Your Ref EN010133

Tuesday 30<sup>th</sup> January 2024

**Re: Deadline 4 Response, Cottam Solar Project**

Figure 3-2: Options Considered on Ordnance Survey Base

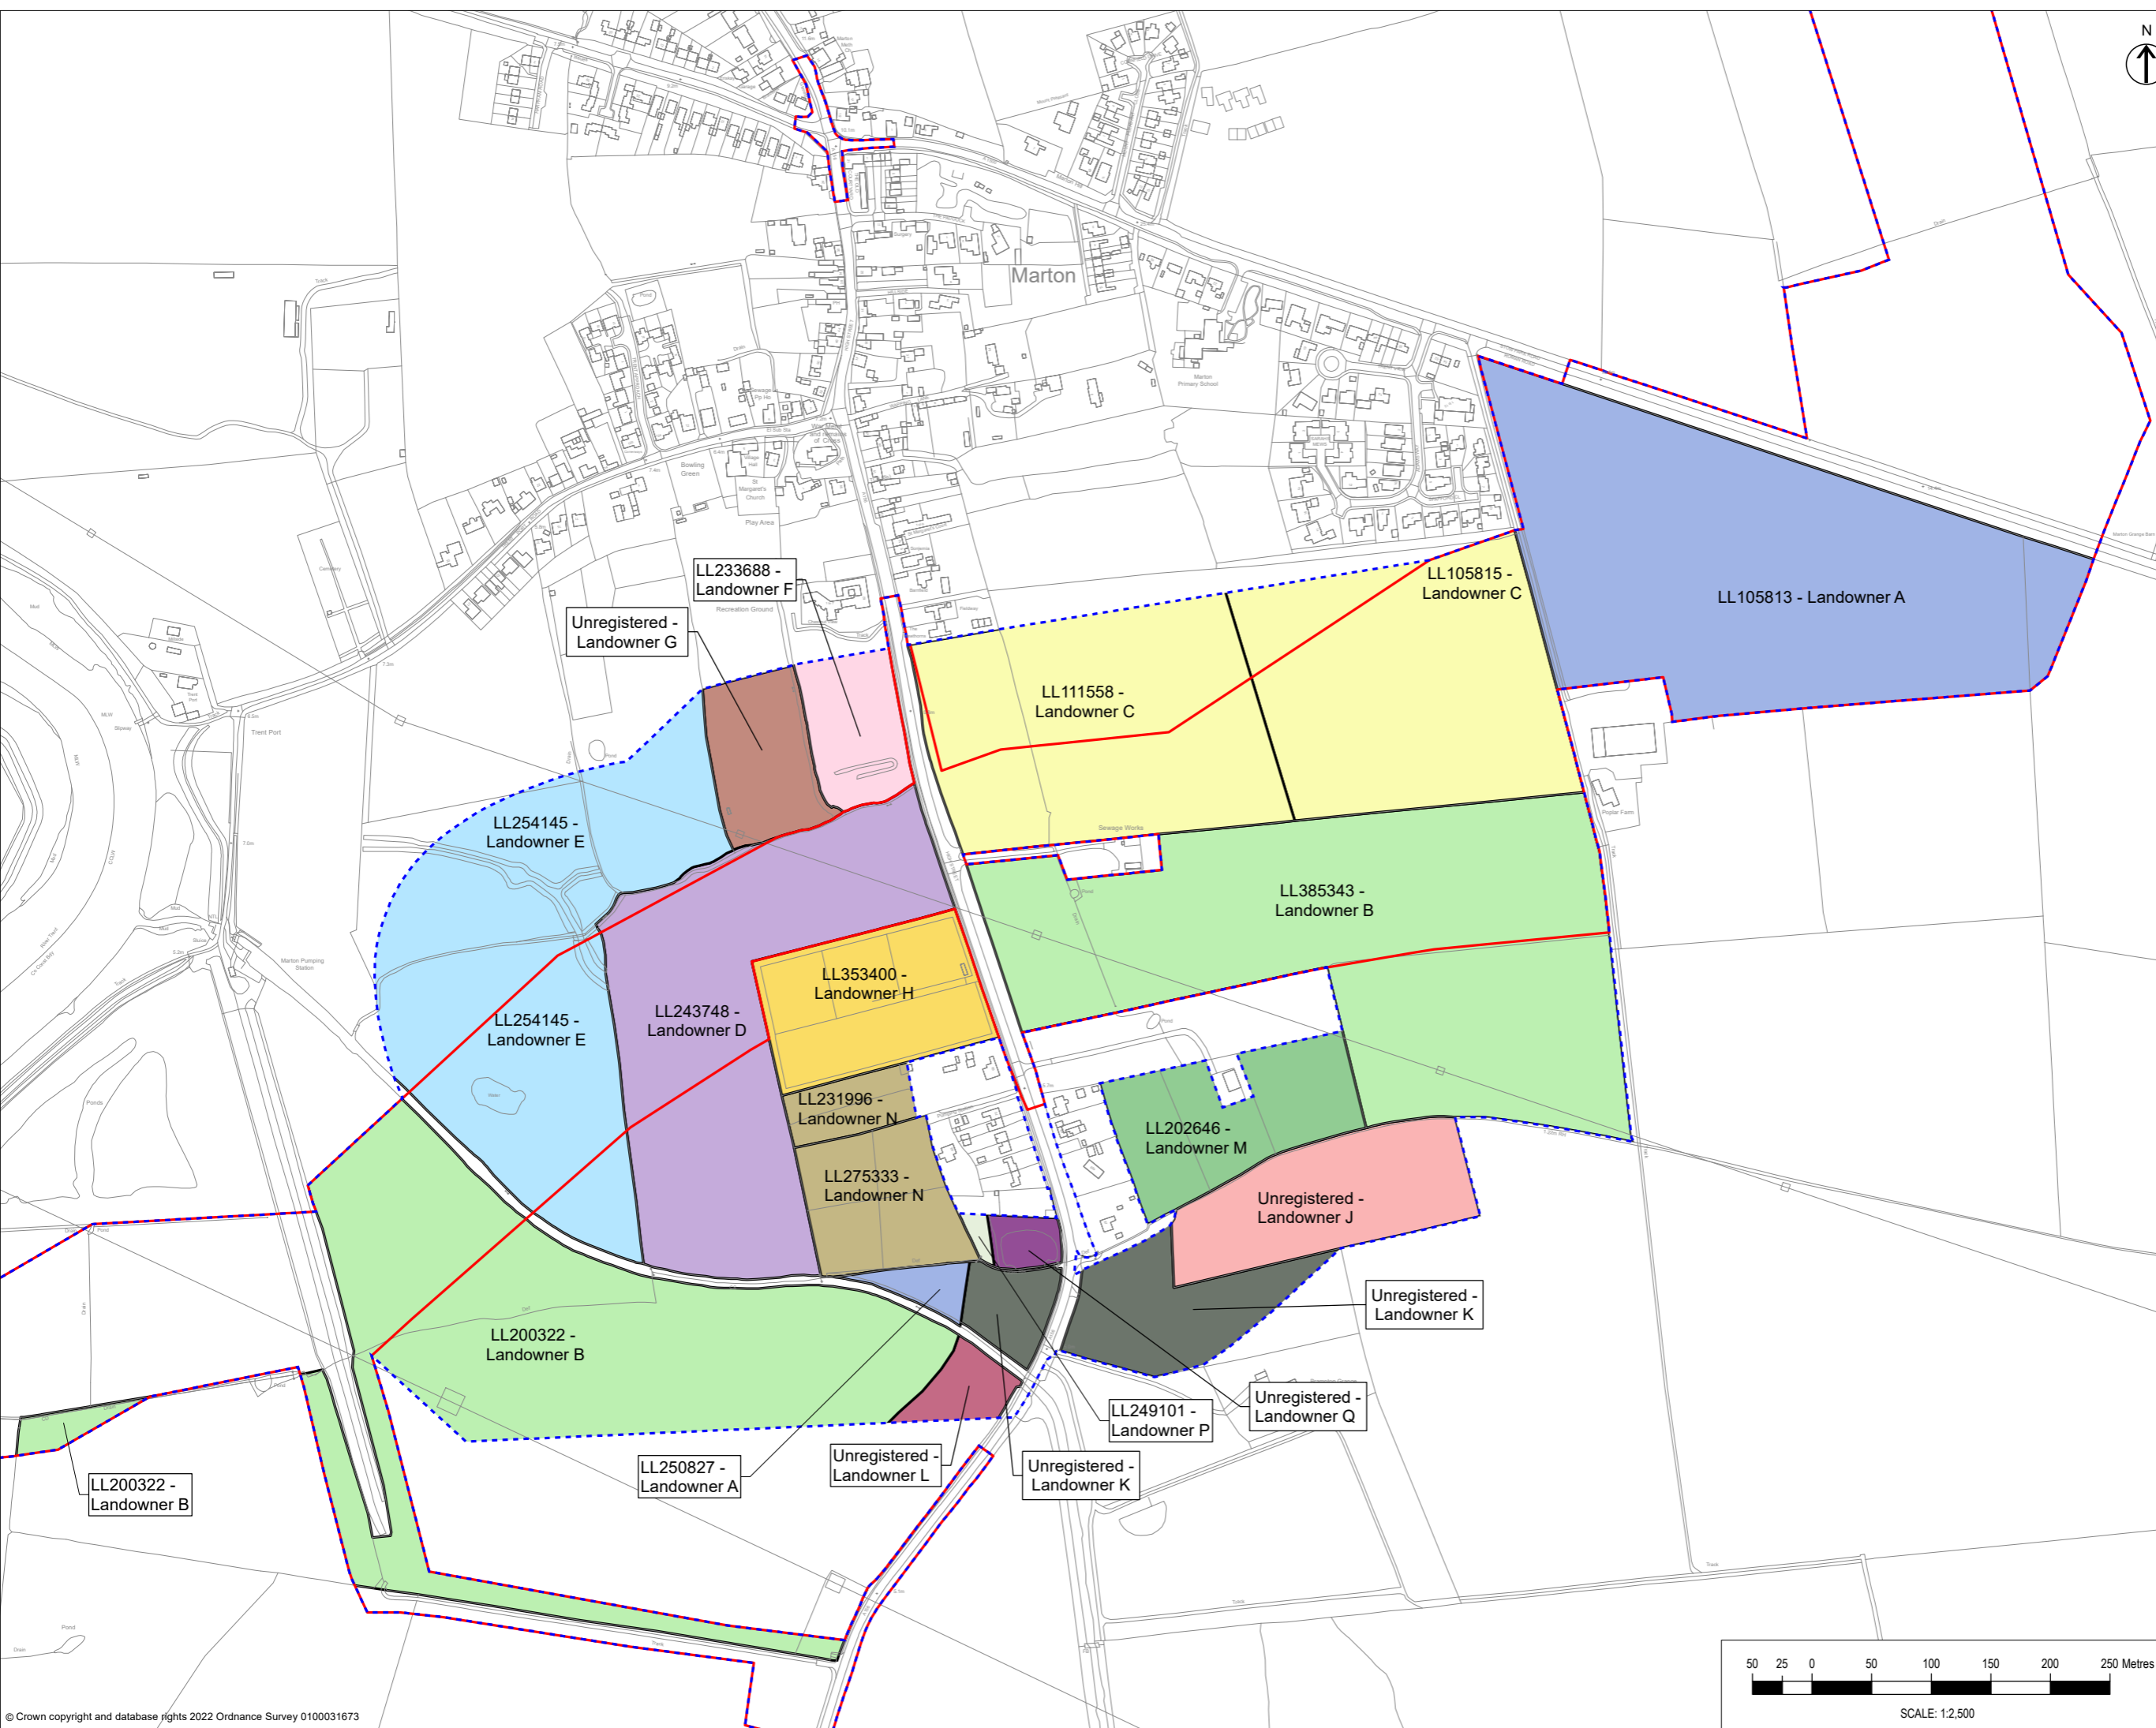
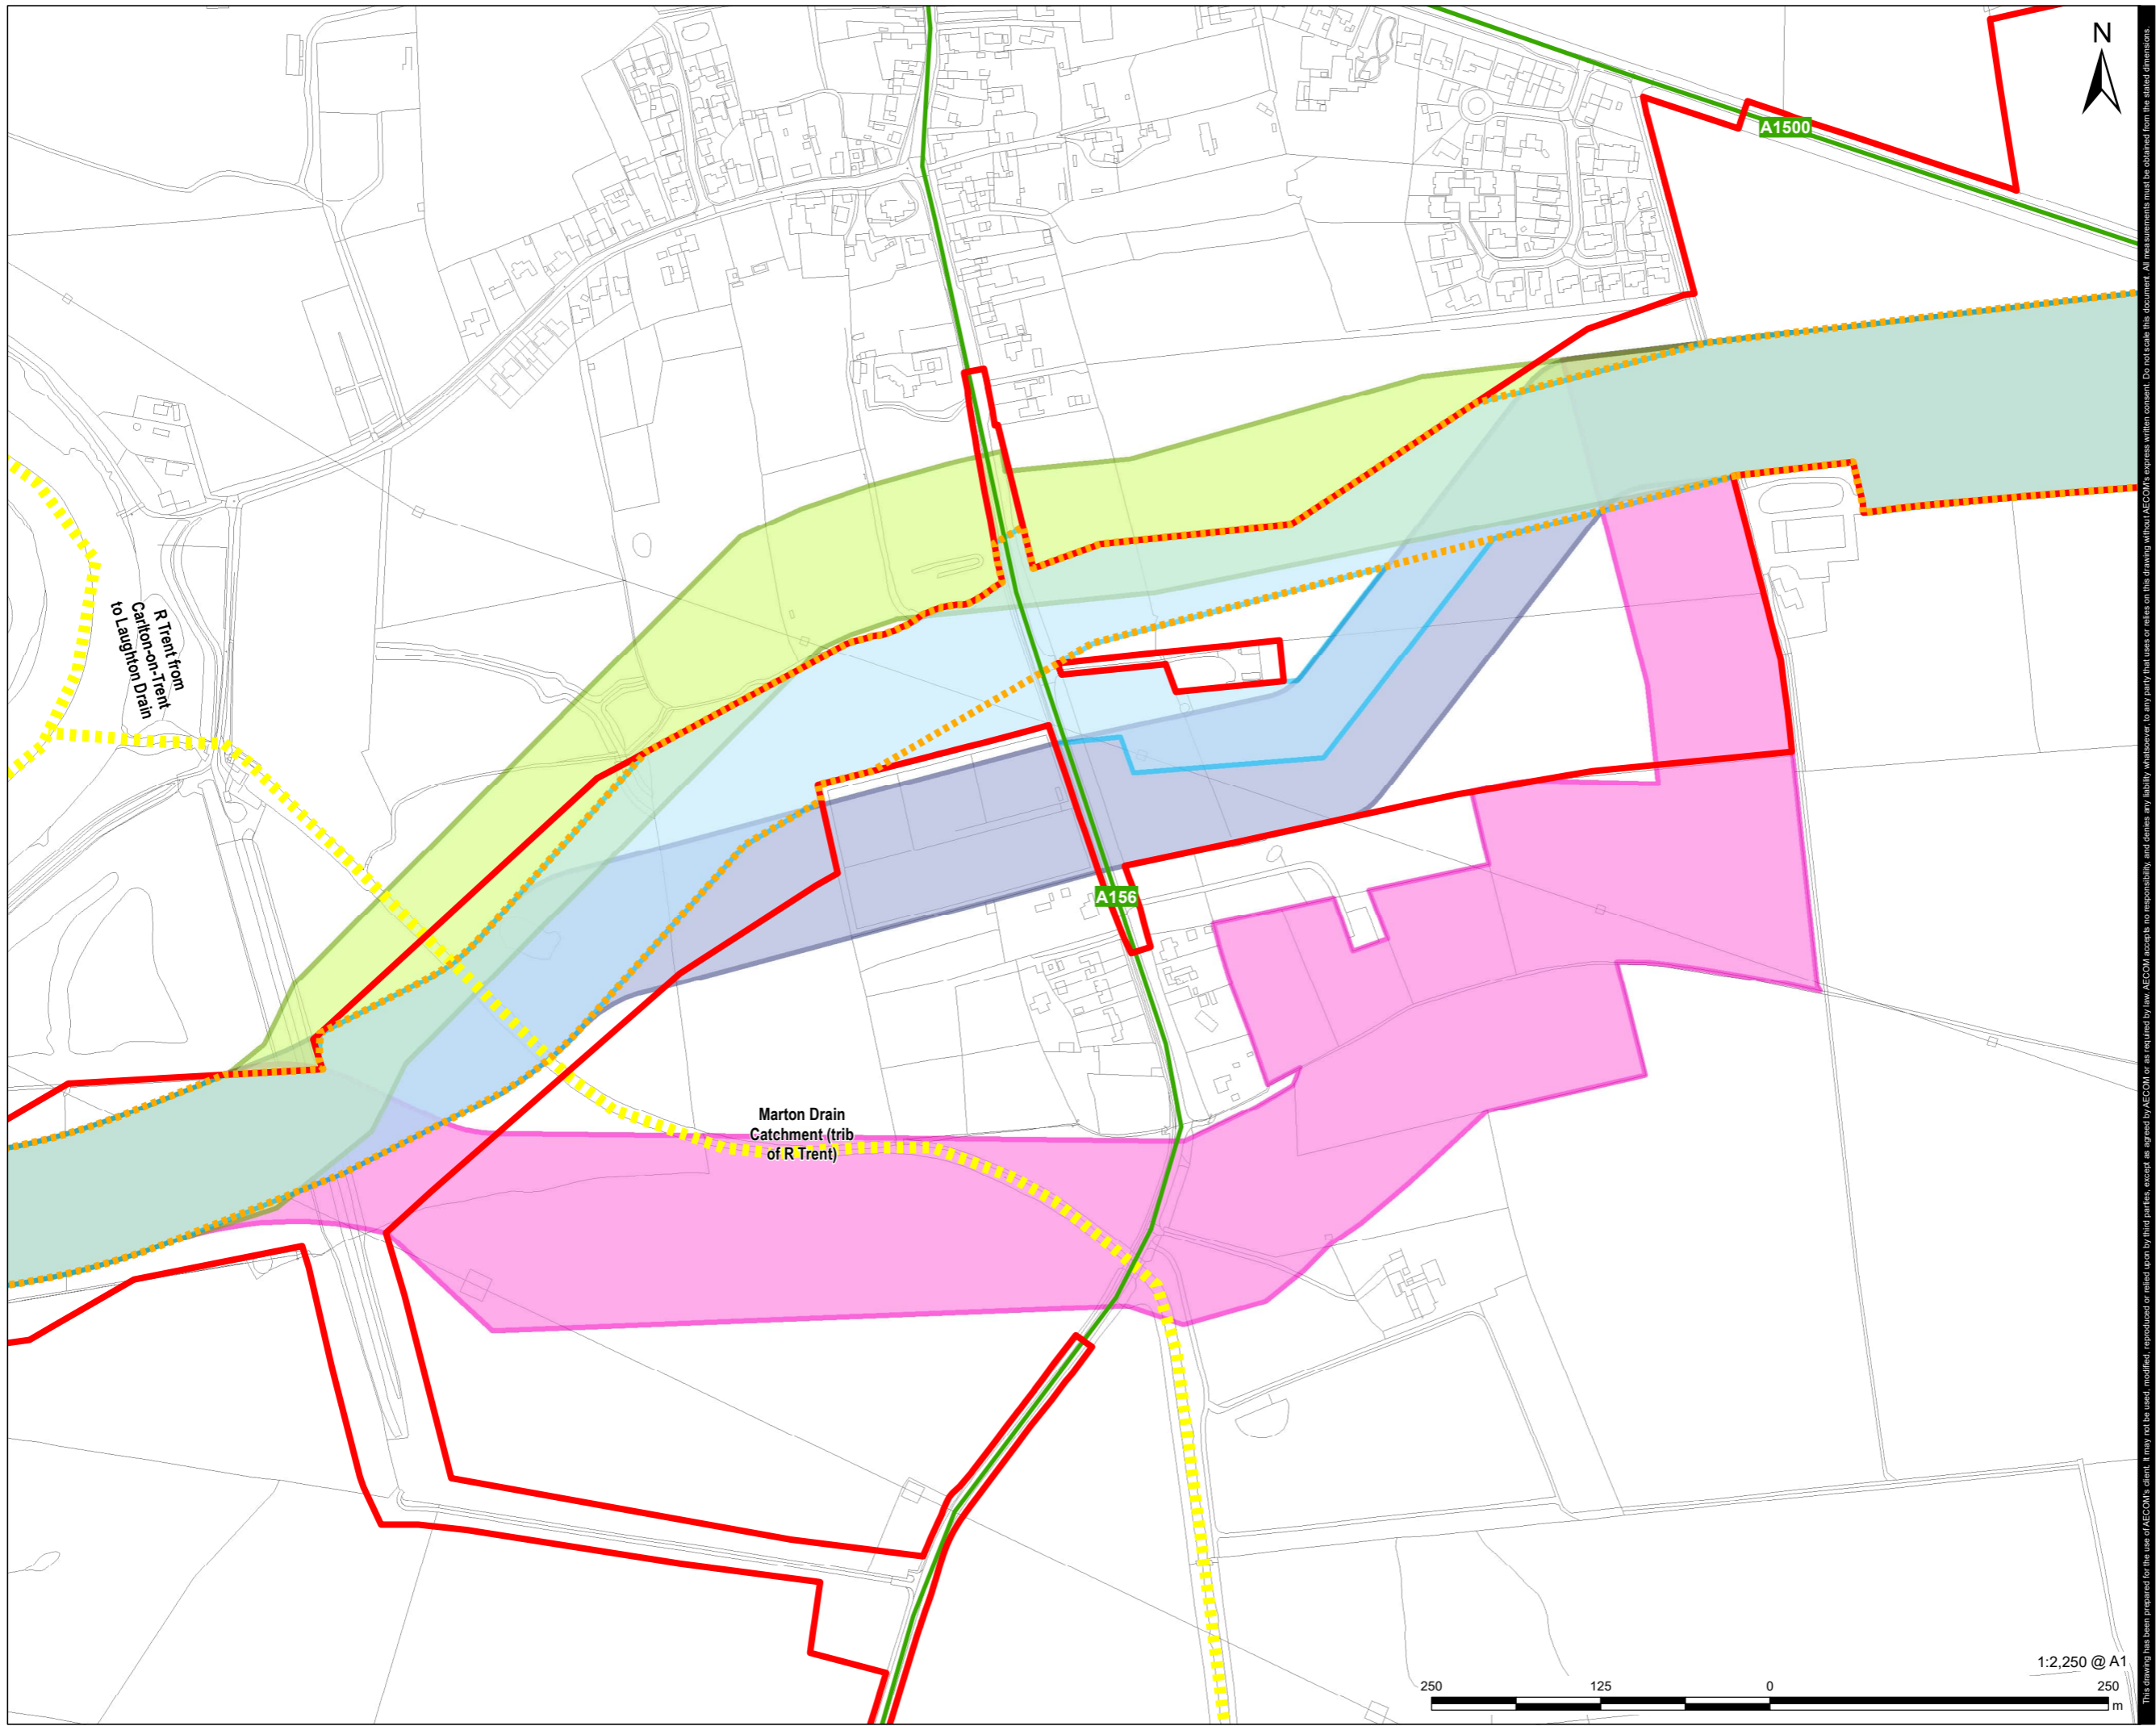
Option 2 (if the order limits are altered) does include land in the southeast corner of the eastern dredging tip. The inclusion of this land within order limits raises the potential need for Protective Provisions for the Trust and a Land Agreement if the route is altered. This is a similar situation to that proposed for the southwest corner of the Trust's western dredging tip as part of the West Burton Solar Project. The same would be the case for options 3, 4 and 5 which also appear to include land in the southeast corner of the eastern dredging tip, but do not appear to be the preferred options. We would wish to work with the applicant (and other NSIP applicants) to ensure this matter is discussed and included within future amendments.

FIGURE NUMBER
Figure 1a

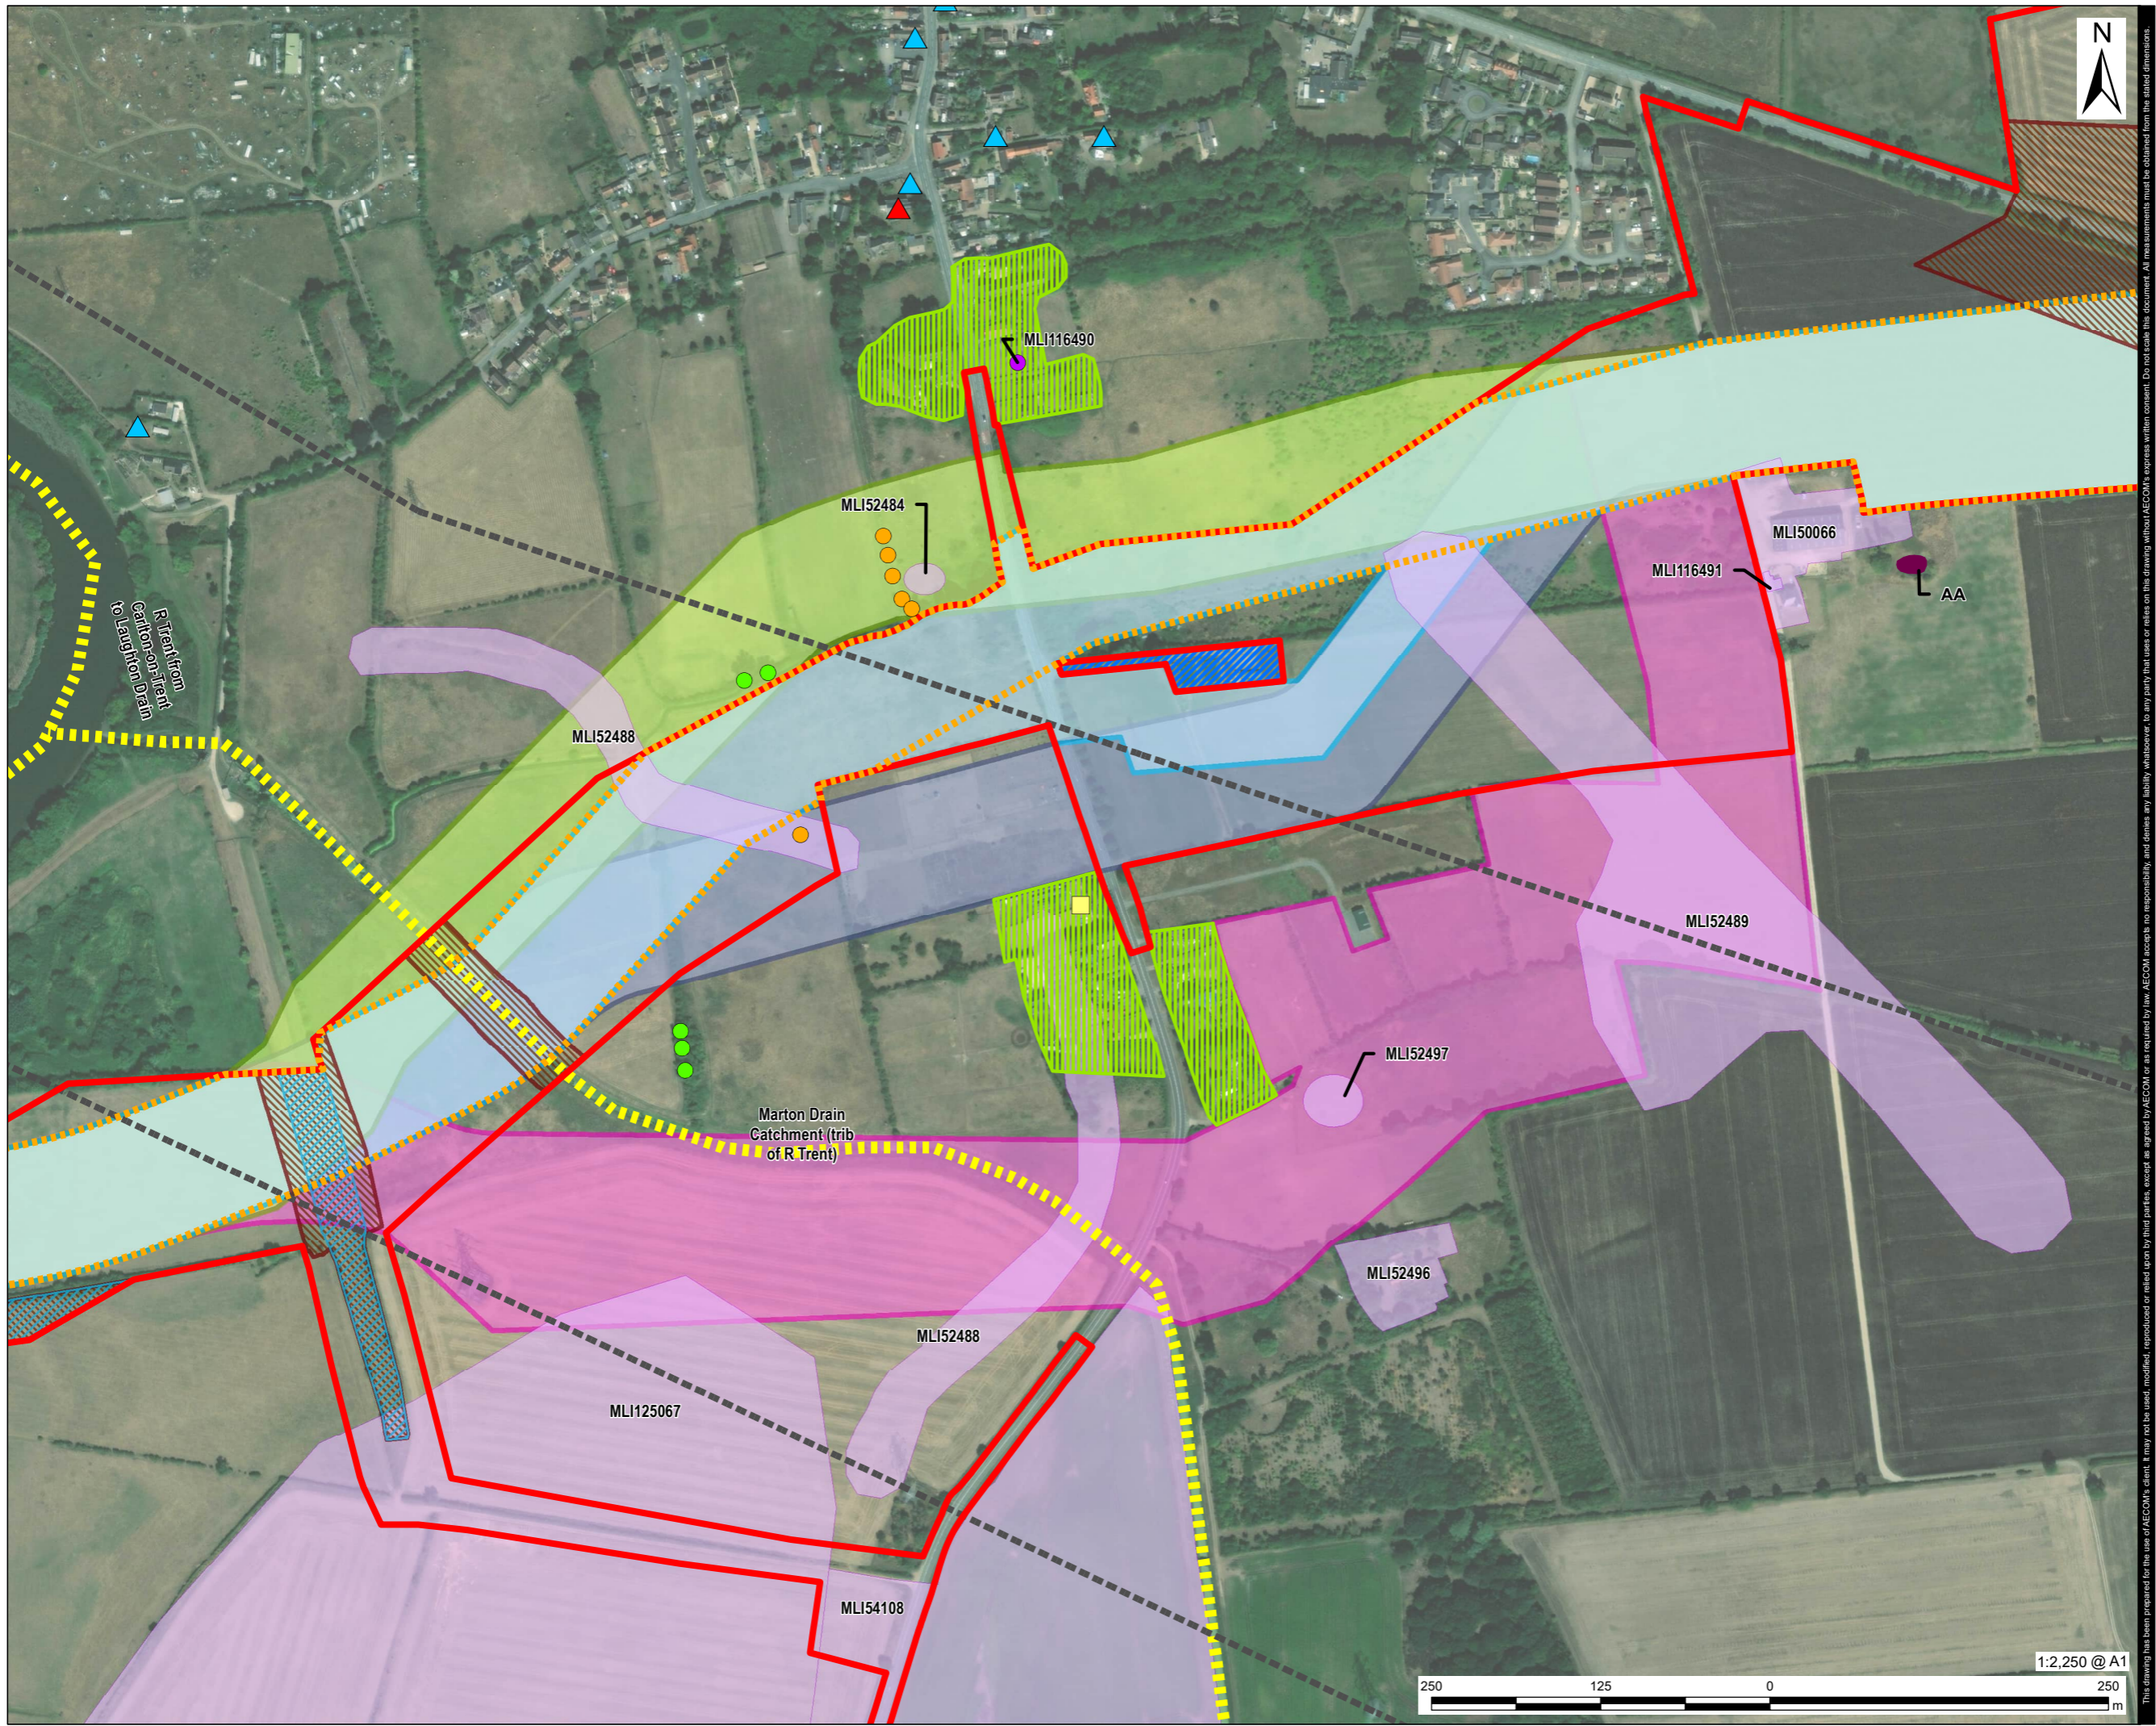
The report considers the cable route options to the south of Marton village and east of the River Trent. In our Relevant Representation we advised that we own a dredging tip on the east side of the River Trent, which initially lay immediately north of the cable route corridor. The below extract is taken from the Environmental Constraints Plan – Figure 3-1 and shows the current red line order limit excluding the eastern dredging tip. The dredging tip is not mentioned as a constraint on the Environmental Constraints Figure 1a.
